From: Katie Kurek [REDACTED]
Sent: 22 November 2017 11:46
To: Mark Jones
Subject: FW: Planning Application R/172/17/HH 84 Worthing Road, Rustington

84 Worthing Road, Rustington, Littlehampton, BN16 3LL

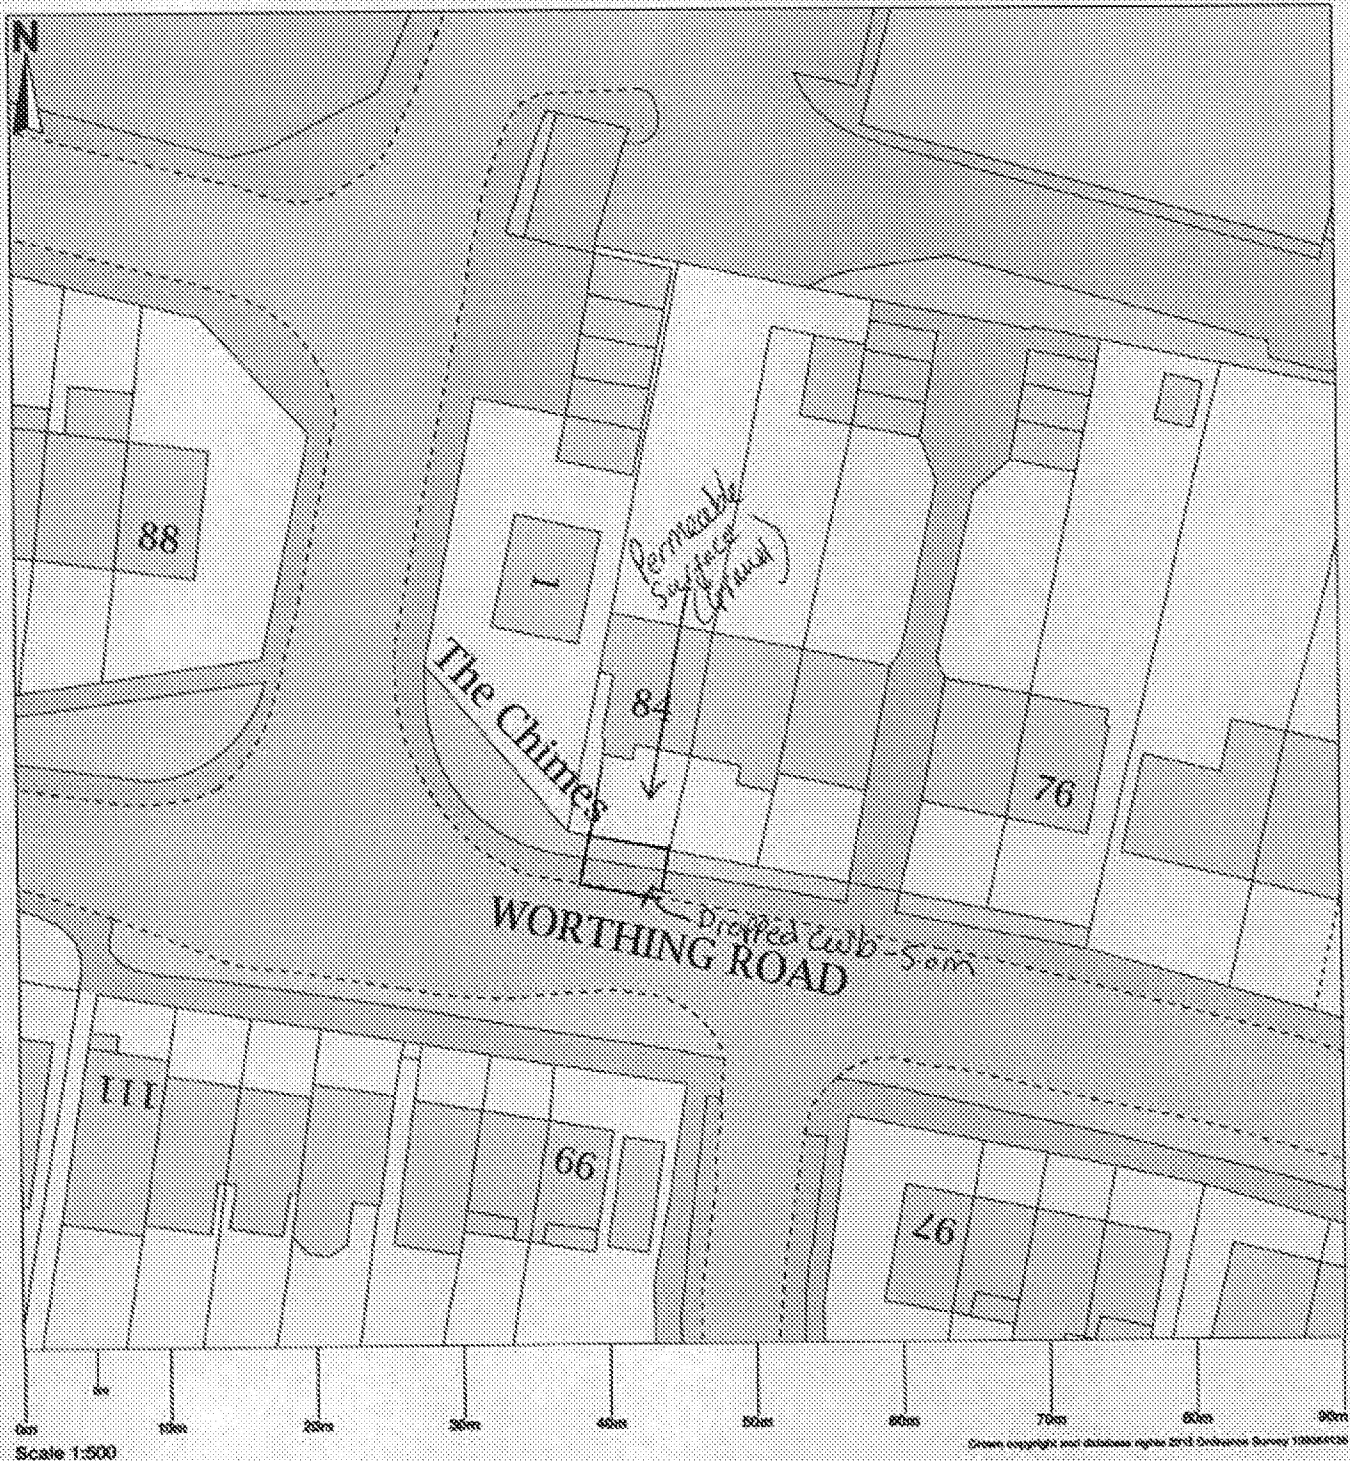
the lamp column would need to be moved in order to facilitate the creation of the VCO. If you look at the attached photo, the boundary line is pretty much in line with the cable running down the house and therefore the lamp column is an obvious obstruction.

From local mapping the lamp post seems a lot more central to the plot for this application. The applicant would be advised to contact WSCC Highways Area Engineer (copied in to this email). He will be able to advise whether it will be necessary to remove the lamp post and if so these conversations should take place with the utilities company. It is not a highway safety issue for us but rather a matter of practicality of whether the crossover is able to be constructed with it in place. The area engineer will be able to advise more regards specification of crossover and proximity to lamp post.

The owner of number 84 would be advised to contact SSE directly to discuss whether the lamp column could be moved (whether there is an alternative location close enough to its current position to ensure light coverage is not affected). They will also be able to advise of the costs involved.
